Application No.	2021/93254
Proposed Development:	Erection of single storey rear and two storey side extension
Location:	52, Virginia Road, Marsh, Huddersfield, HD3 4AZ
OS Map Reference	SE 412235.5695 417199.3895
Applicant/Agent:	architectural drafting services
Class:	Other Developments

**Consultation Response from KC,
Highways Development Management**
2021/93254 52, Virginia Road, Marsh, Huddersfield, HD3 4AZ
Erection of single storey rear and two storey side extension
**Date Responded:
13/09/2021**
**Responding Officer: Zack
Turner**
Responding Ref: 5-2SW/12

Highways Development Management (HDM) comments as follows.

PROPOSED SITE BLOCK PLAN
SCALE 1:200@A1

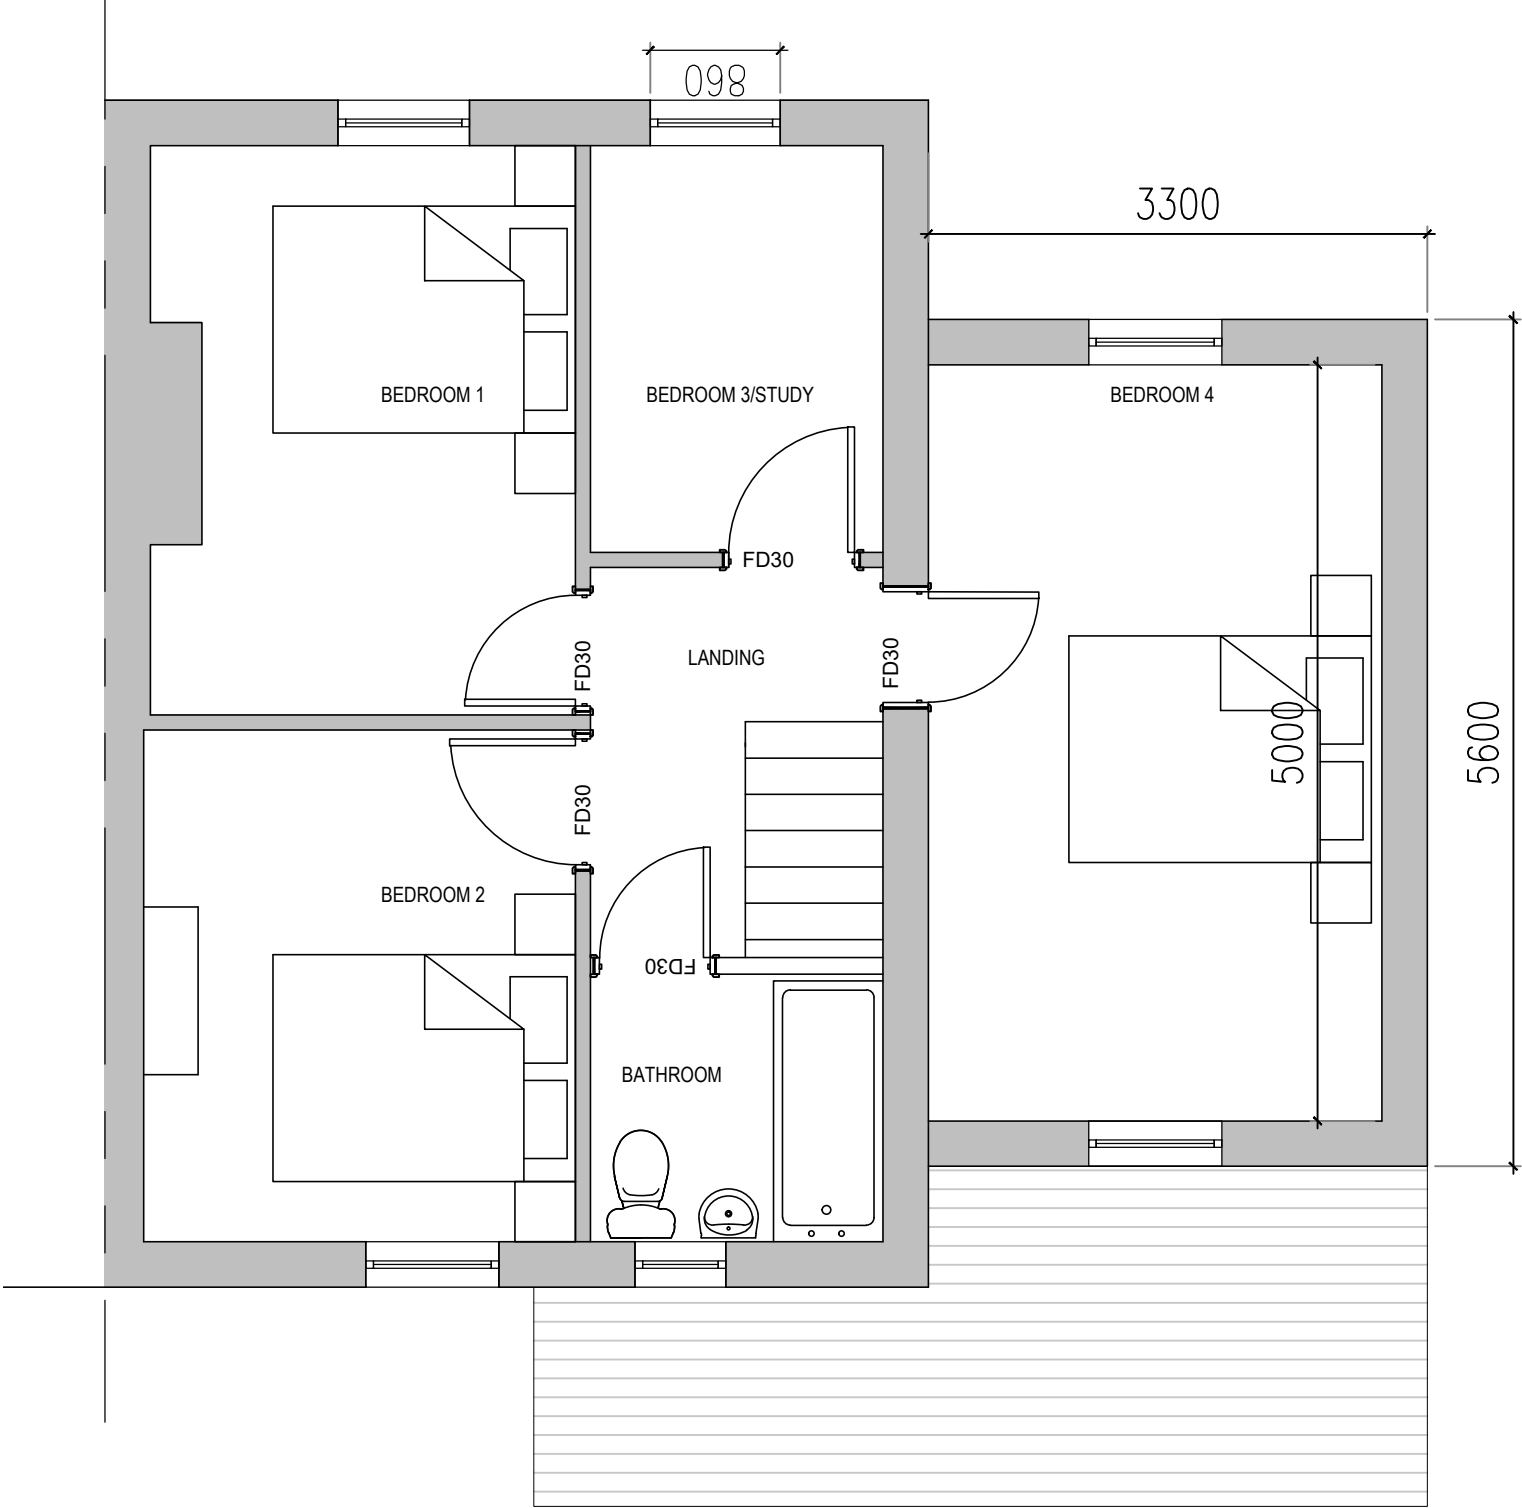
The sites vehicular access from Haywood Avenue will remain unaltered.

The dwelling currently has 3 bedrooms, and these proposals will create a 4th. This requires an increase in parking provision from 2 to 3 spaces.

The single garage has a width of 2.7m which is insufficient to be classed as a parking space as it is under the recommended 3m. The driveway can also not be classed as a parking space due to its length being 4.2m which is under the recommended 4.8m.

There is sufficient on street parking adjacent the dwelling on Haywood Avenue in which there is 18m available to park 3 cars and there is also space to the front of the dwelling for another car.

Within the site there is adequate area to create off road parking in the future however this may require an additional planning permission.

Given there is sufficient on street parking available adjacent and in front of the site, HDM on balance considers the proposals acceptable on this occasion with no specific conditions.
